TIERRA WEST, LLC

January 6, 2022

**RE: The Wymont
8220 Montgomery Blvd NE
Erosion Control Plan (G19E004A)**

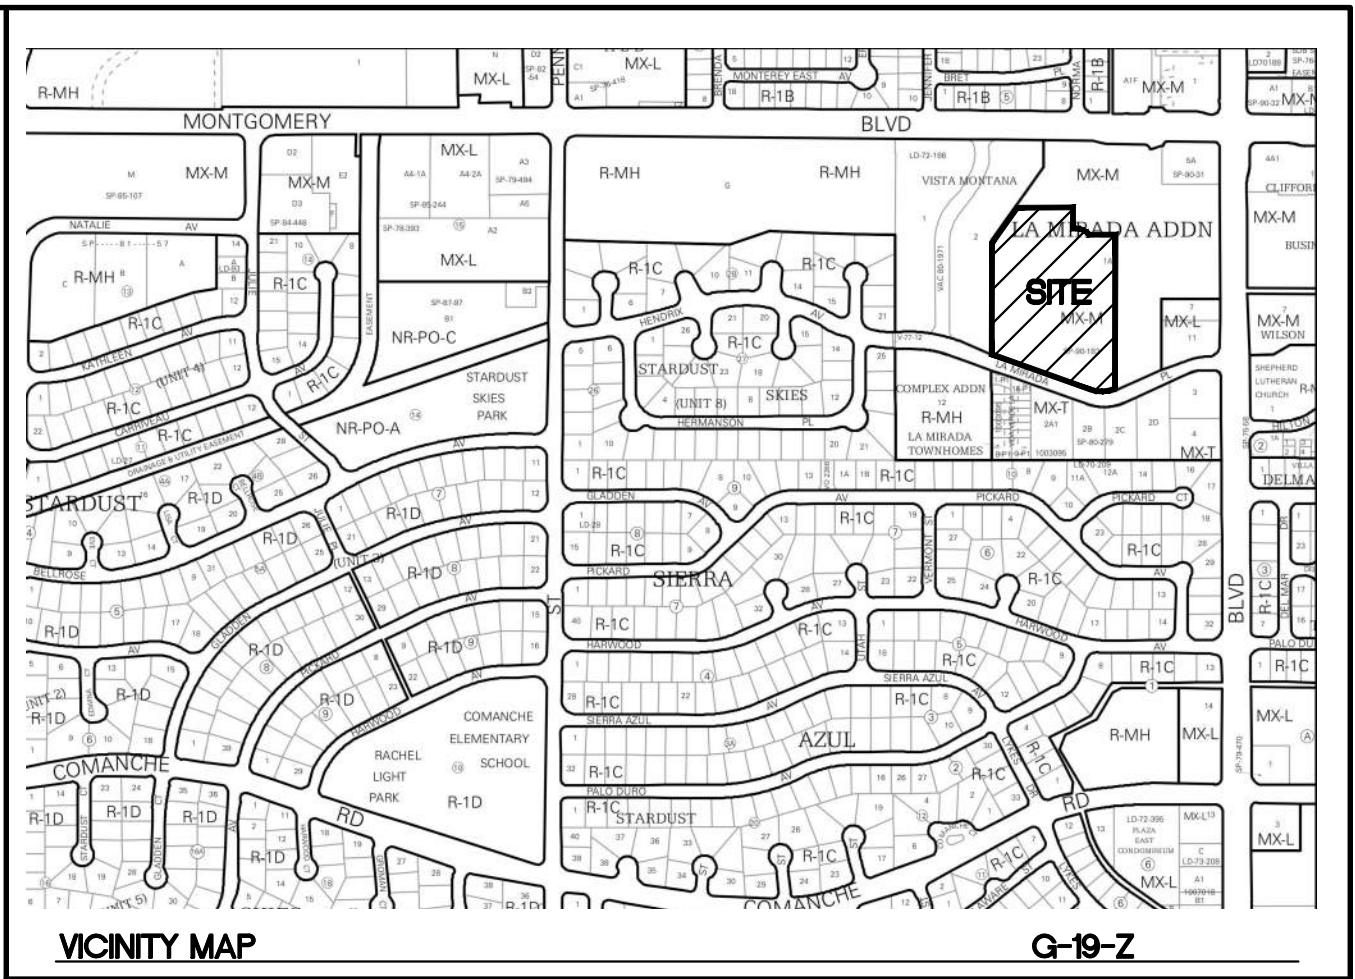
4. Modify note 5 to say that "The entire site will be graded to drain to the existing and proposed pond at all times during construction." **This note was modified as requested.**

5. Identify locations of concentrated flow paths that enter and exit the disturbed areas. Identify locations where sheet flow enters and exits the disturbed area. Show on-site drainage patterns of storm water before and after major grading activities. **Concentrated flows are now shown on the plan as are the sheet flow.**

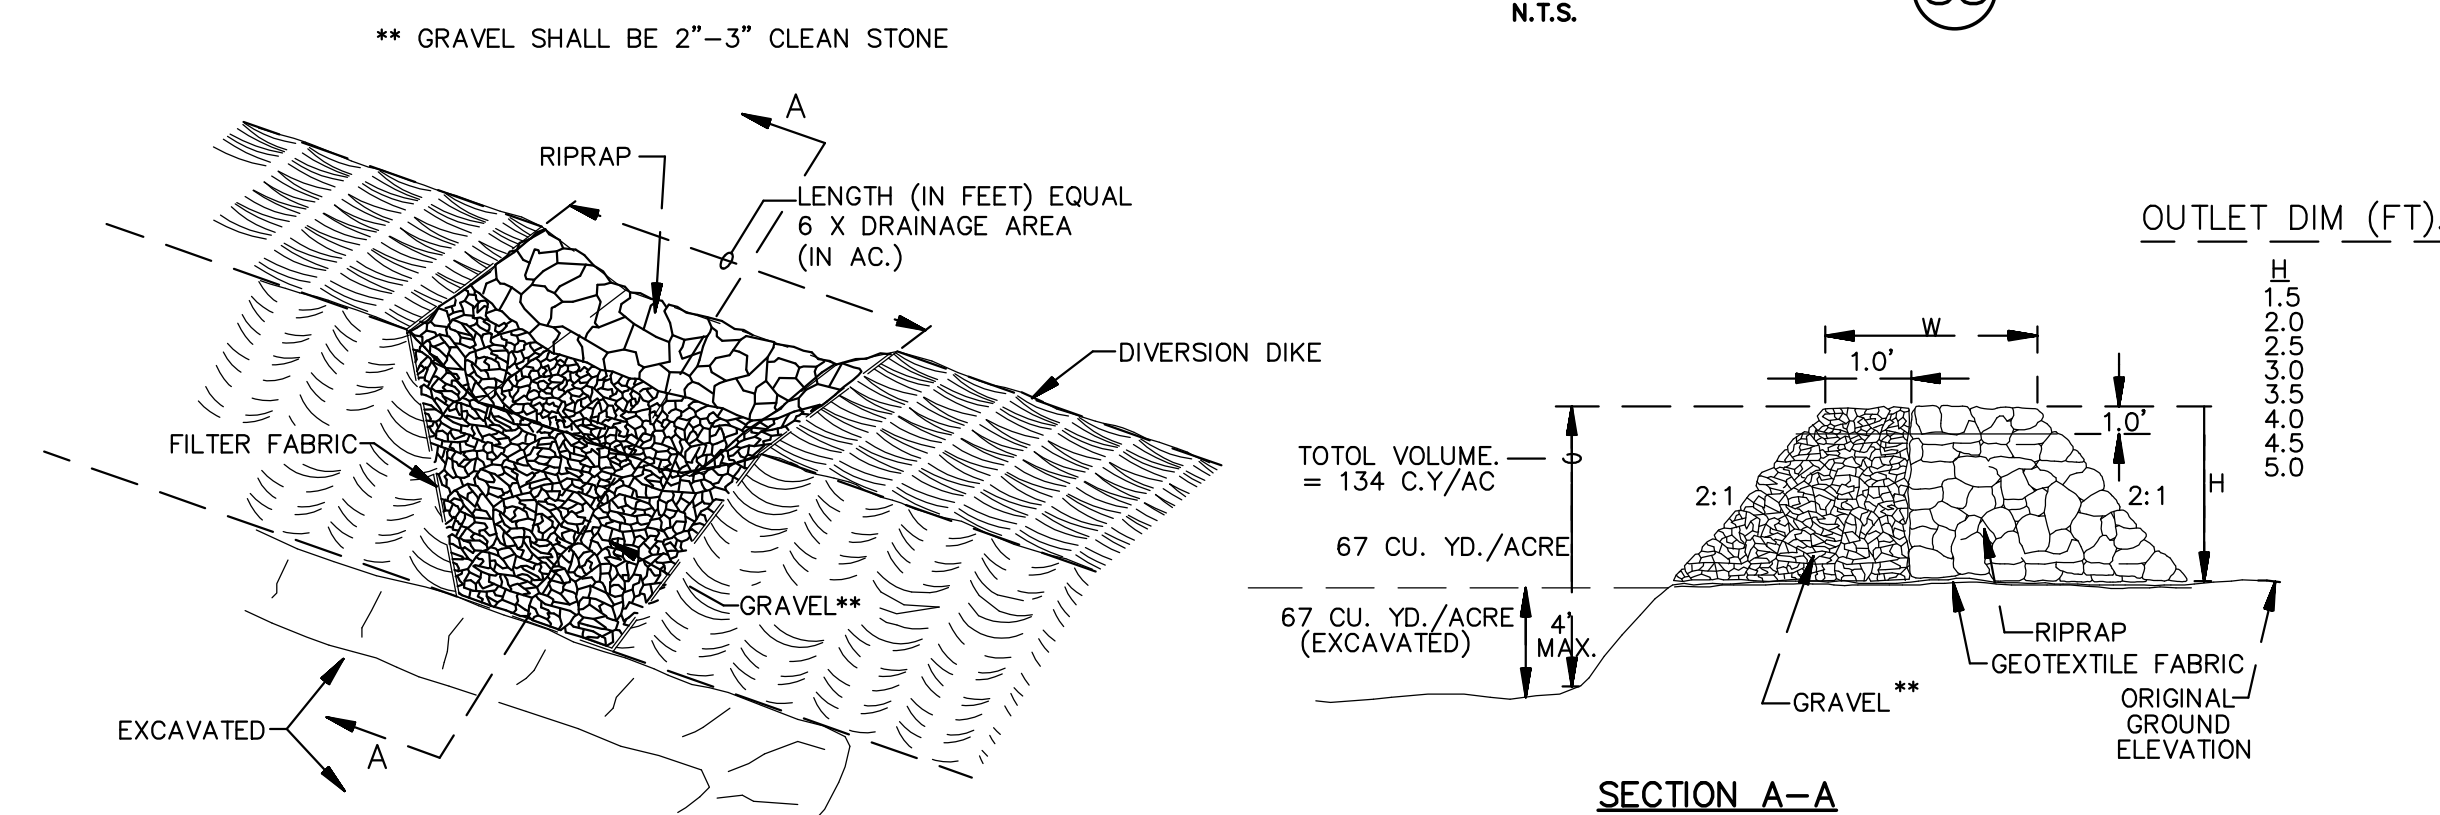
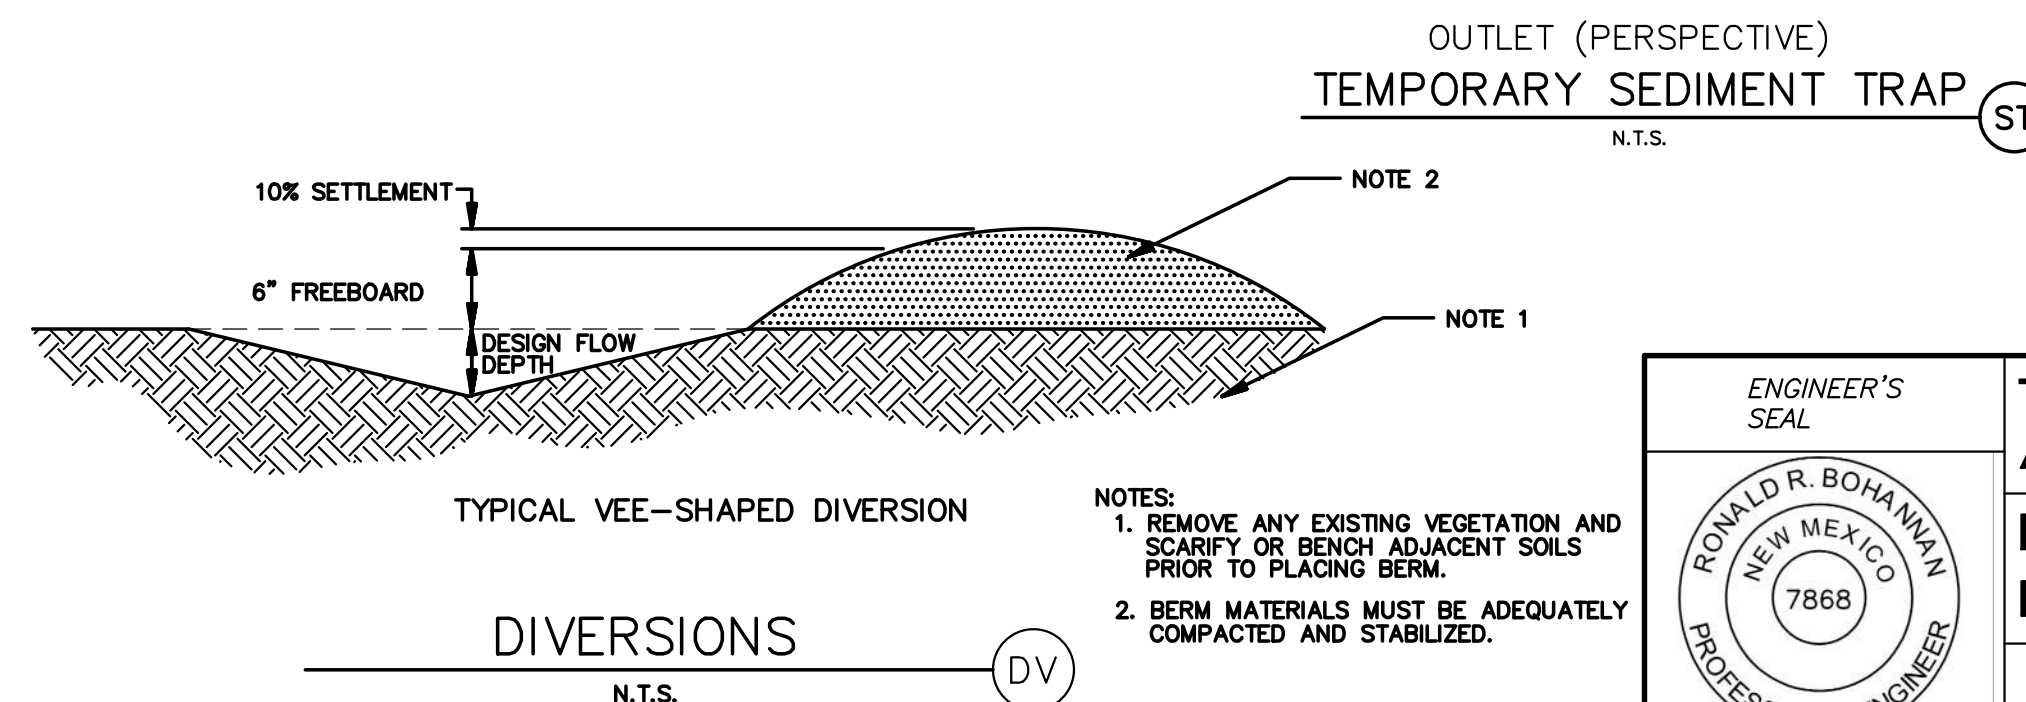
7. Show an interim plan with cut-back swales and silt fences to prevent sediment from getting into the streets and common access drive aisles and sidewalks after the infrastructure construction is complete. Add a detail for the cut-back. Consider adding perimeter silt fence around each commercial lot especially upstream of each inlet. Consider adding a temporary sediment trap upstream of the north east corner of the residential area. **Cut-back swales and silt fences are shown around the tracts that will be developed in the future and a detail of the cut-back swale can be found on Sheet 4.**
